**Subject:** CM/27/18/PL , CM/30/18/PO

CM/27/18/PL Change of Use from farm shop (sui generis) to pet shop (A1)

CM/30/18/PO Modification of planning obligation to allow for use as a pet shop

PLAN 01

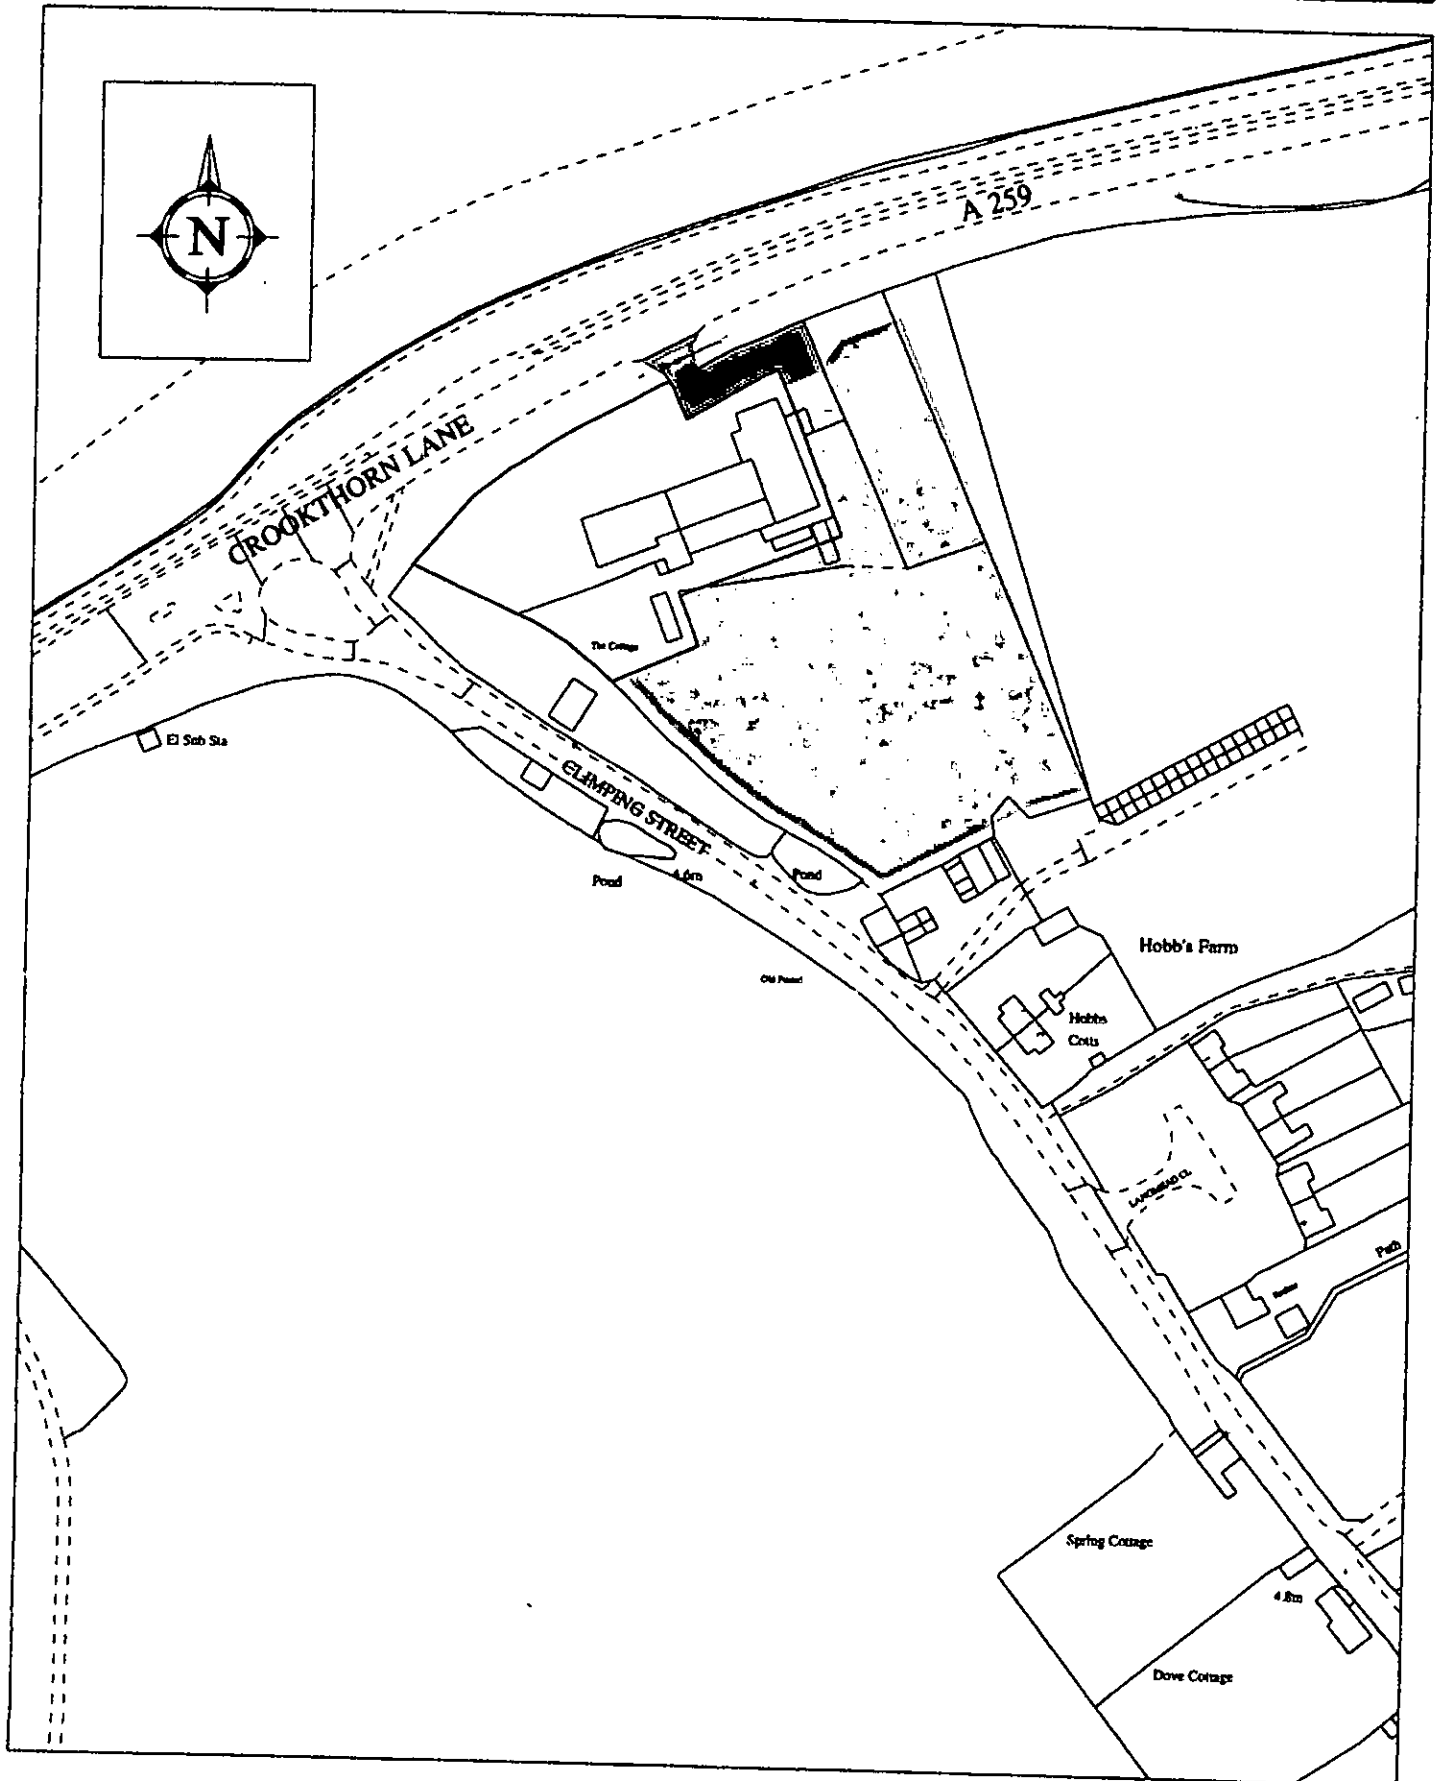
The Site Plan should include the parking area, all parts of the building included in the application, including storage areas and the site access to the A259 within the red edge. You will also need to serve Notice on West Sussex County Council and submit Certificate 'B' to us. Application CM/27/18/PL will be put back on hold until this is resolved.
